**Consultation Response from KC,
Lead Local Flood Authority**

2025/92161 Land adj, 17, Whitehall Road West, Birkenshaw, BD11 2LS

Date Responded: 29th August 2025

Drawing No: 23/341/050/001 Revision: N

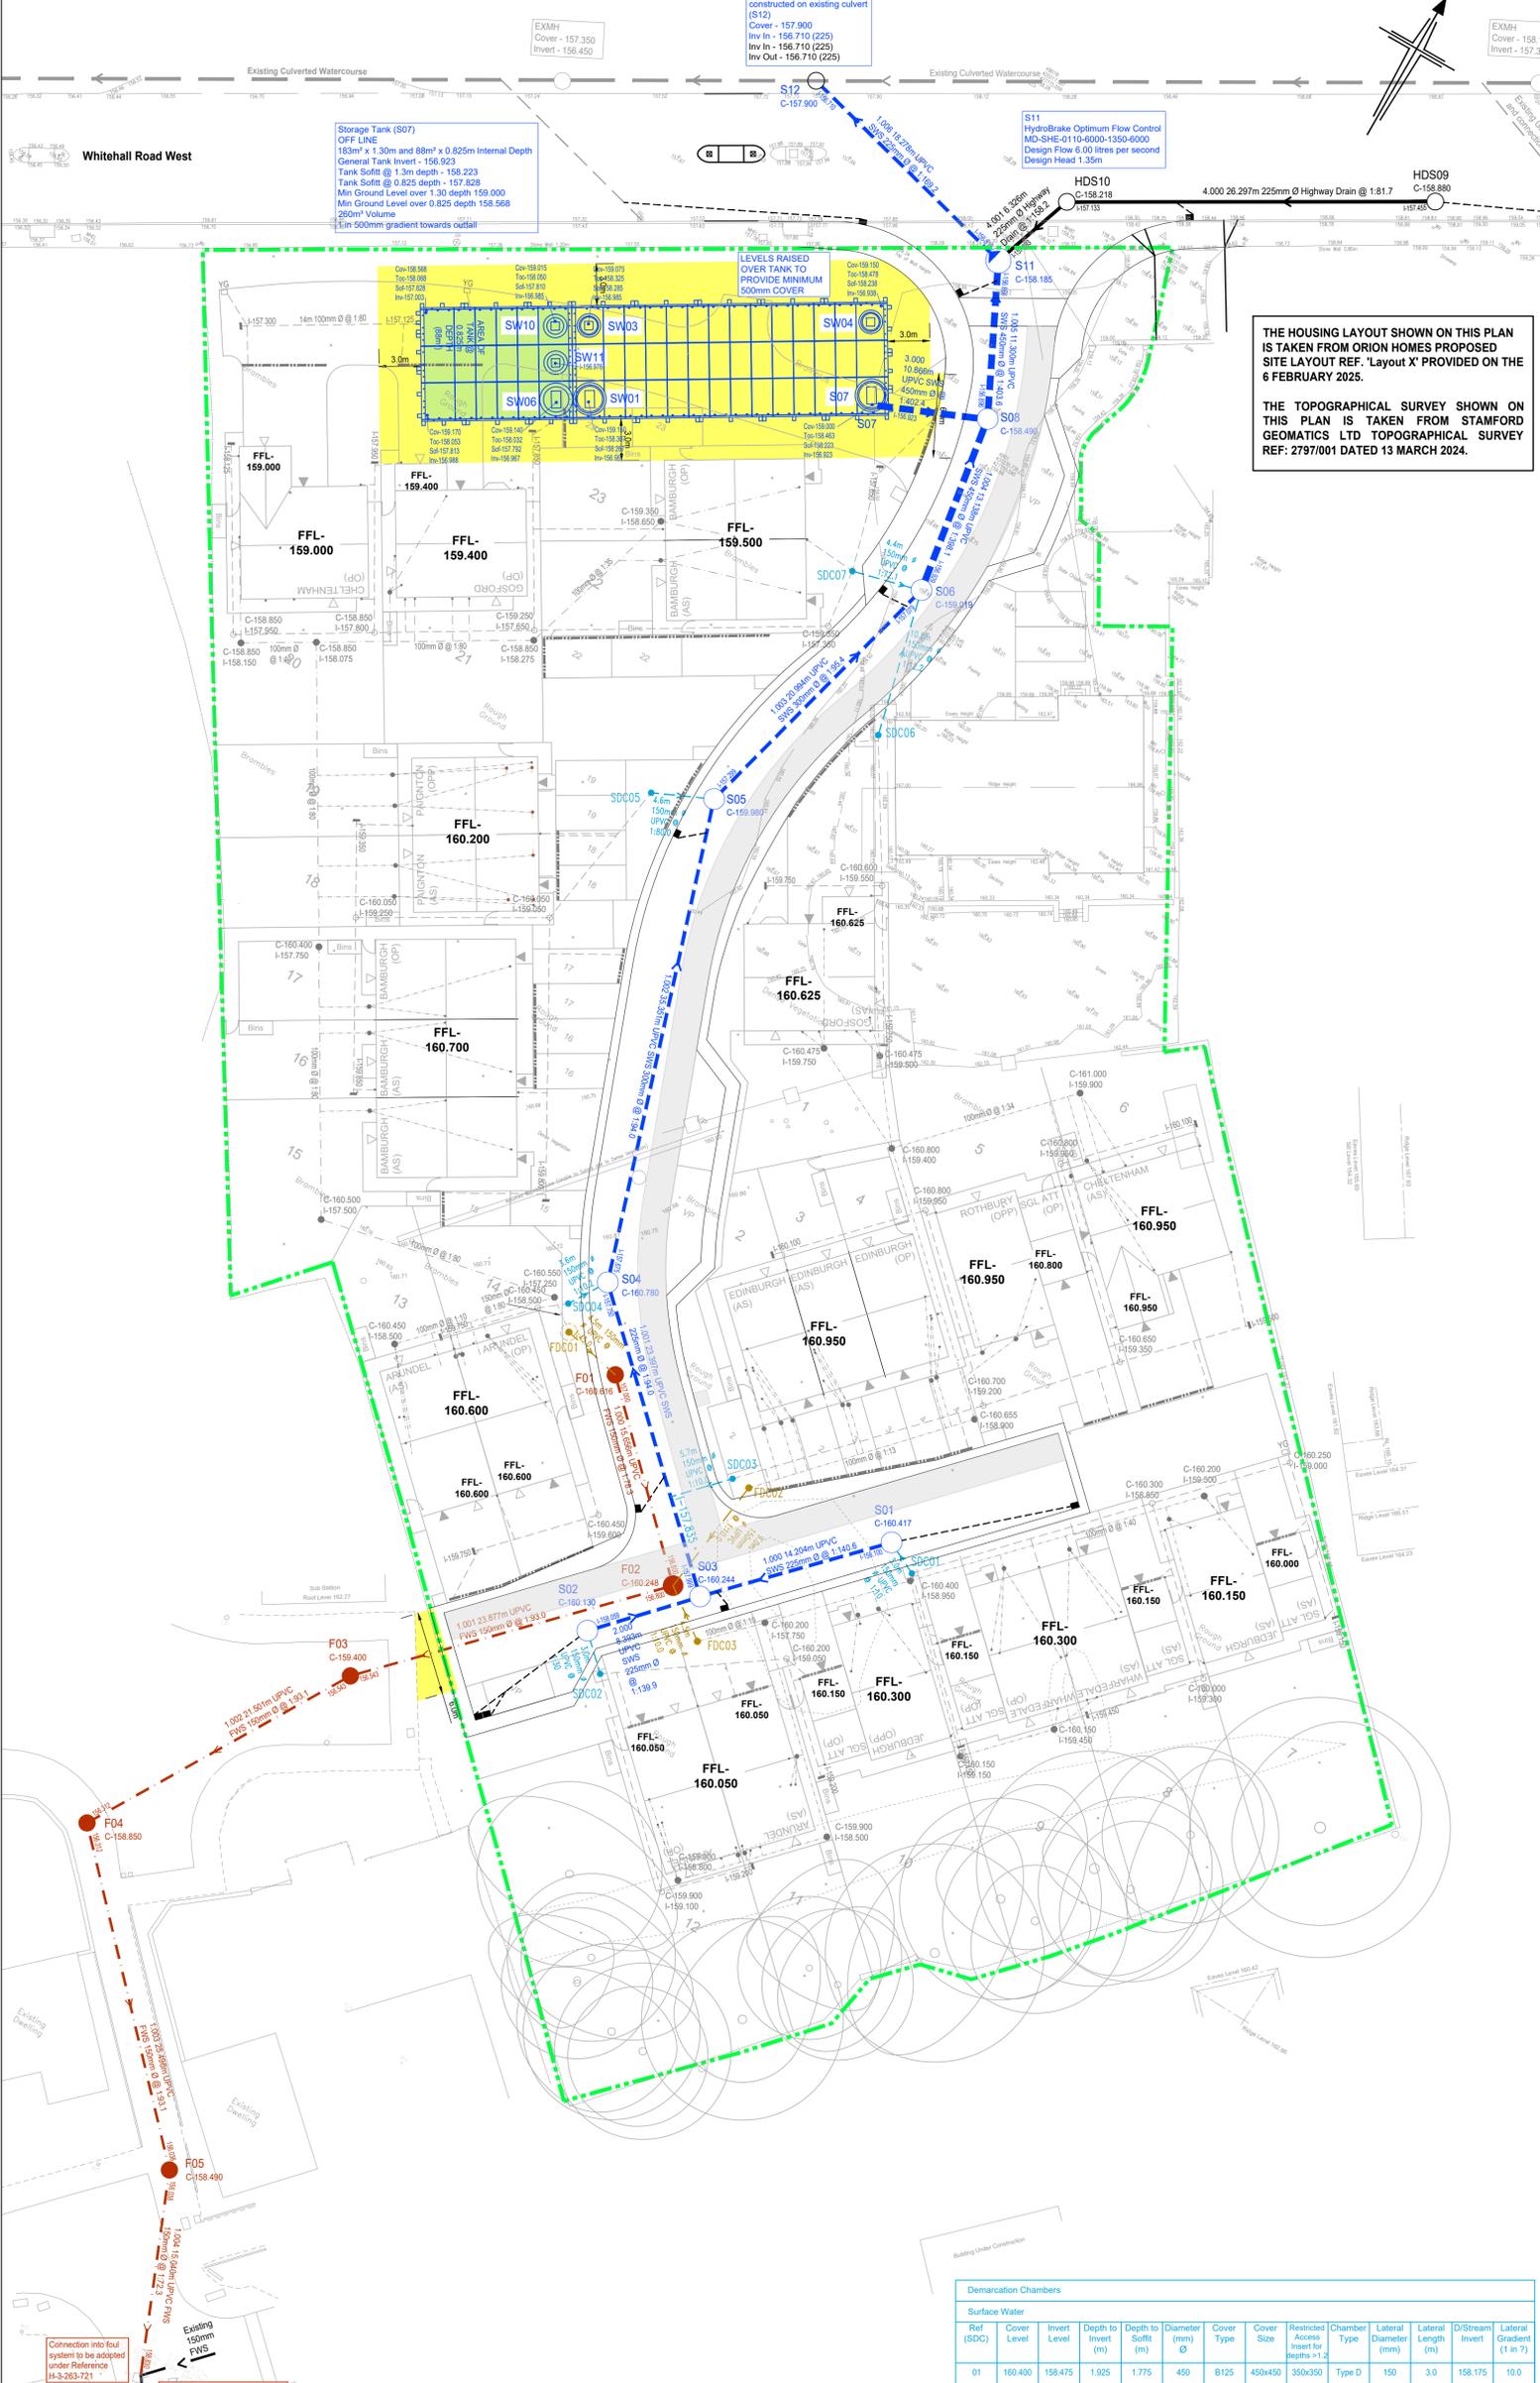
Condition 28 – Tank Maintenance

A statement that Yorkshire Water will look after the tank is unacceptable. The LPA has a legal obligation under NPPF to ensure the maintenance and management of SUDS for the lifetime of the site. This includes the period between installation and adoption. The Principal Designer under CDM regulations 2015 should oversee the production of a maintenance and management plan of a completed and installed design. The CIRIA SUDS guide give typical methodologies for such attenuation system. The applicant is expected to make this site specific and relate it to plan and cross section drawings and a set design. This includes access to the tank and into the tank and a note to replace the neoprene seal if the flow control us ever removed for maintenance.
